BARANGAROOSOUTH

PLANNING AND ENVIRONMENT RESPONSE – BAR418–SB-98

Comment From Planning And Environment

View Corridors across Hickson Park

HICKSON PARK EAST ENTRY DETAIL PLAN

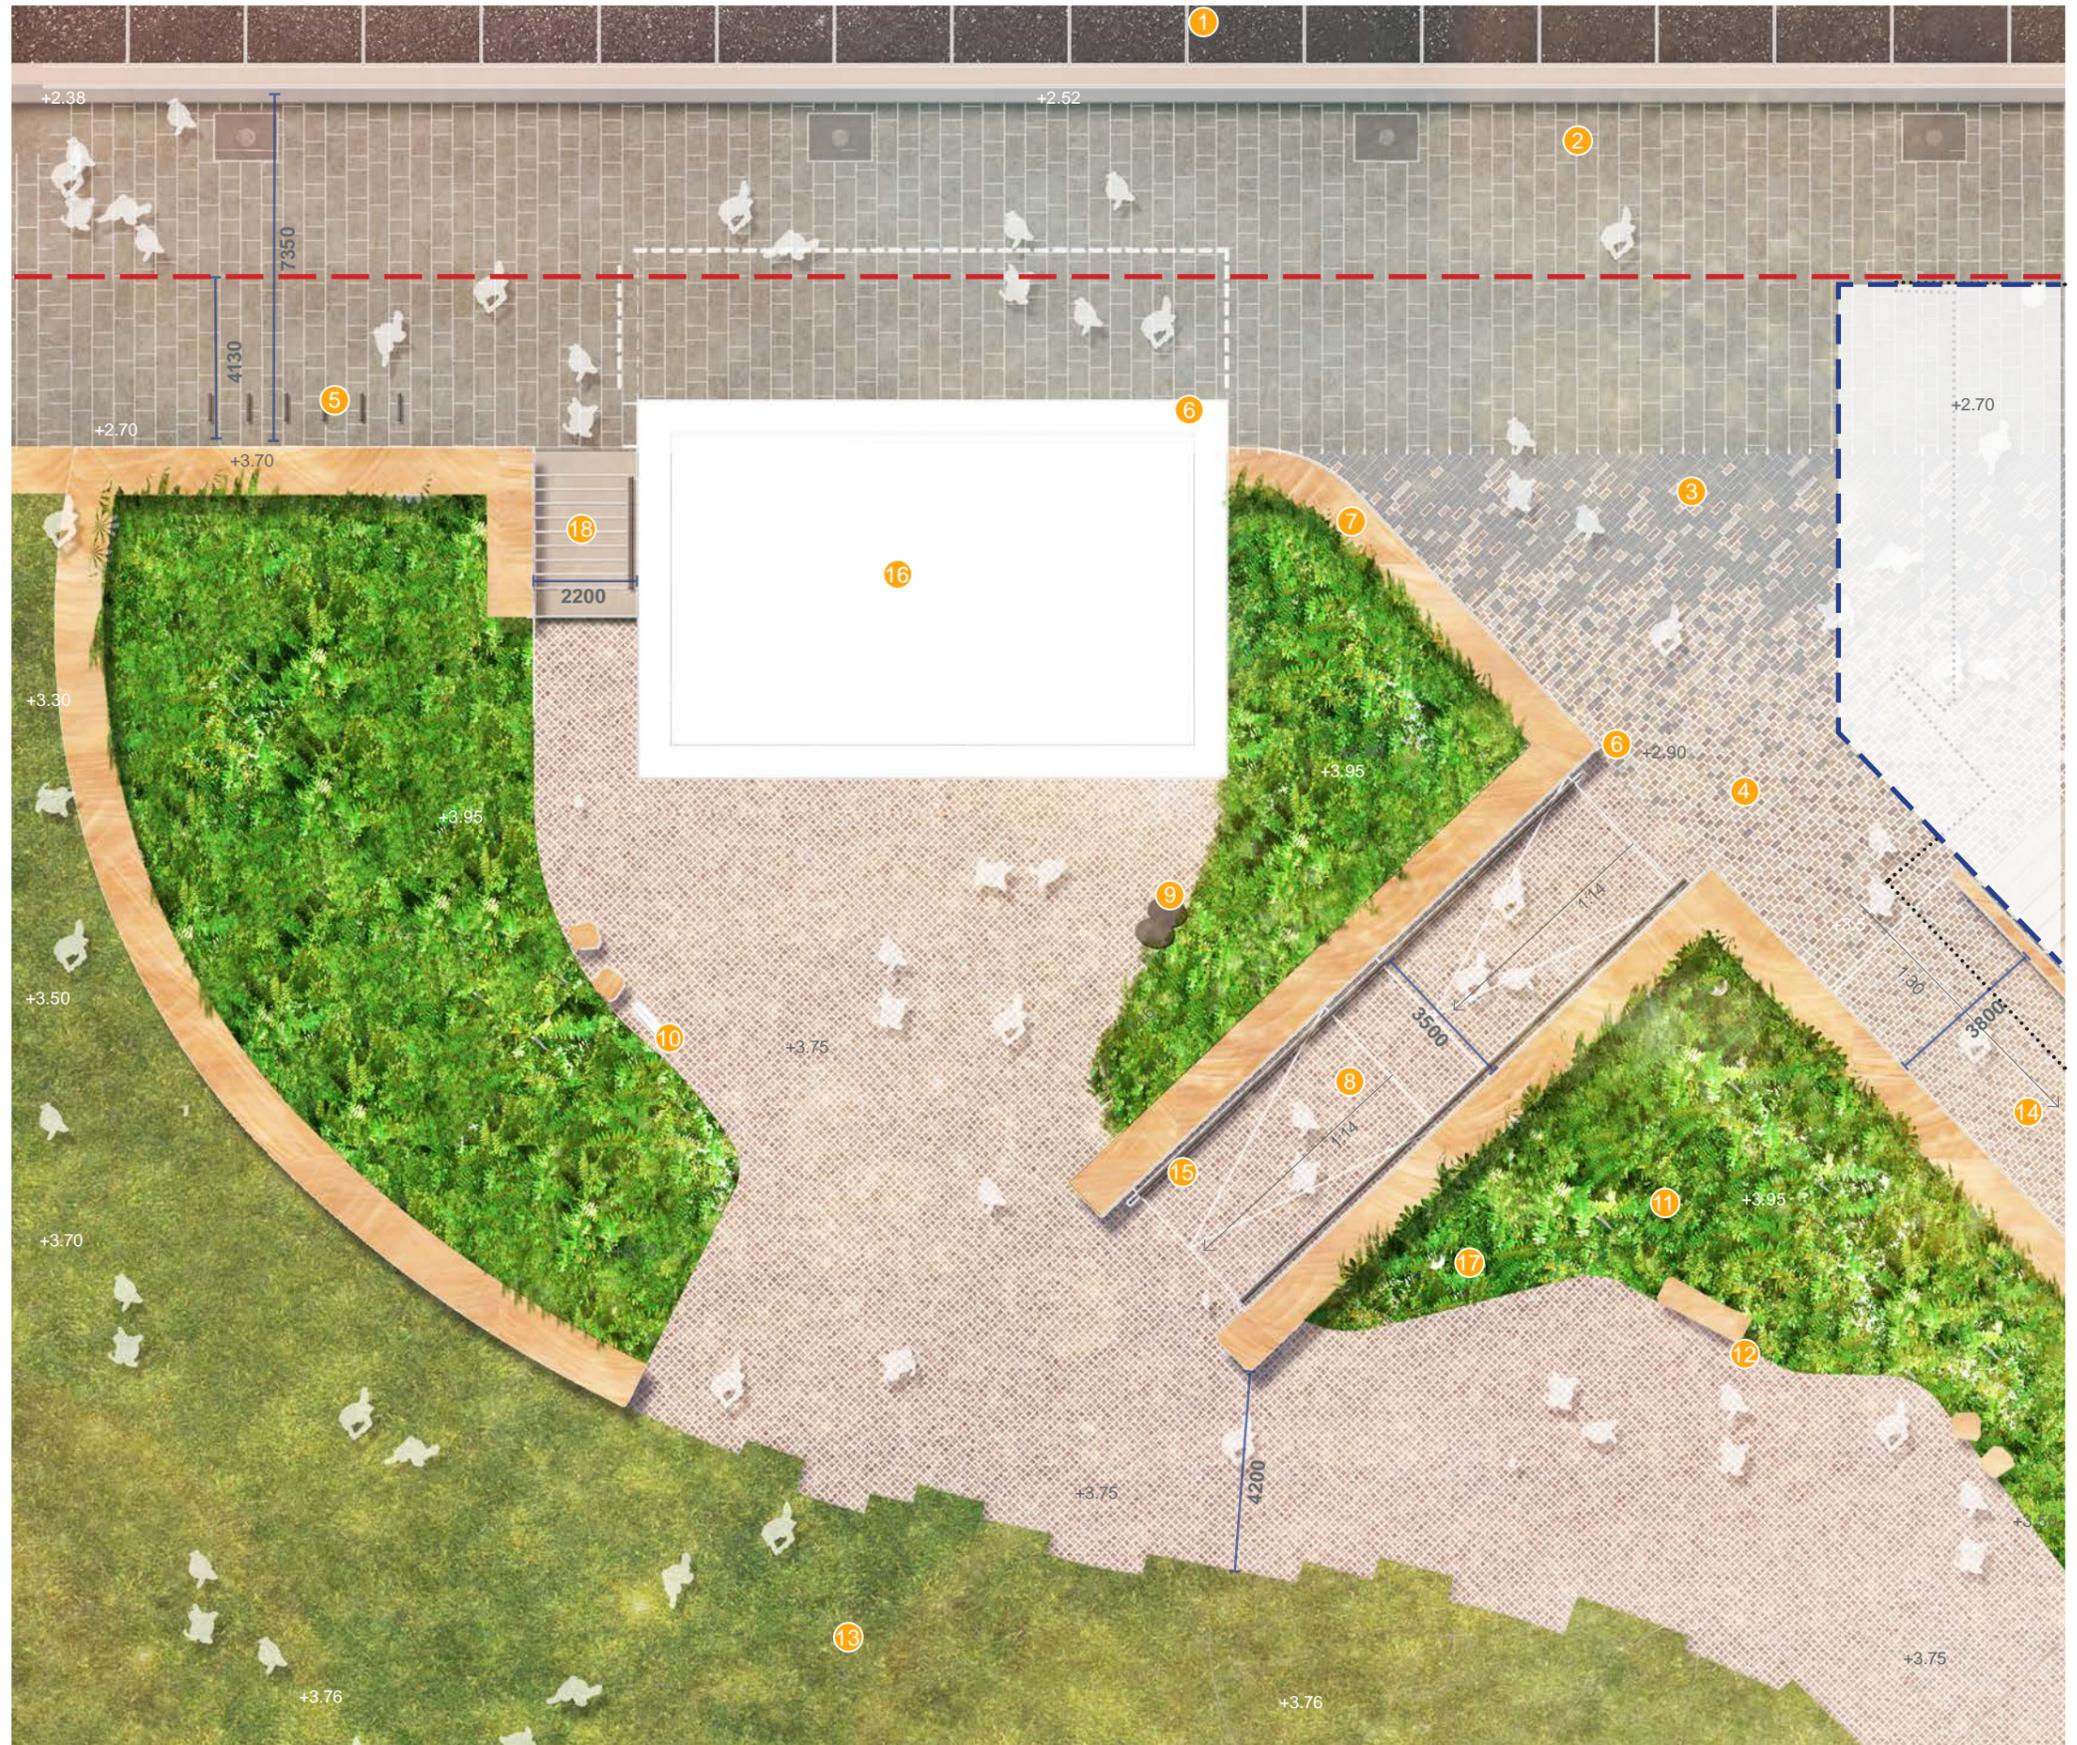
‘Provide further analysis and discussion oh how view corridors from Hickson Road to Sydney Harbour would be provided across Hickson park with the proposed final levels and grading’.

Studies have been developed to capture the view corridors from Hickson Road to the harbour reflective of proposed levels.

View lines have been captured at eye height (1700mm).

Clear and unimpeded views to Central tree allee’ have been maintained.

Proposed levels allow for suitable drainage and crossfalls throughout the park, lowering of proposed levels will result in numerous drainage pits through the central area of the park.

*Please note that grading and levels represented are those issued in the Stage 1B Development Application. Grades and levels may change at Hickson Road/Park interface subject to futher design development.
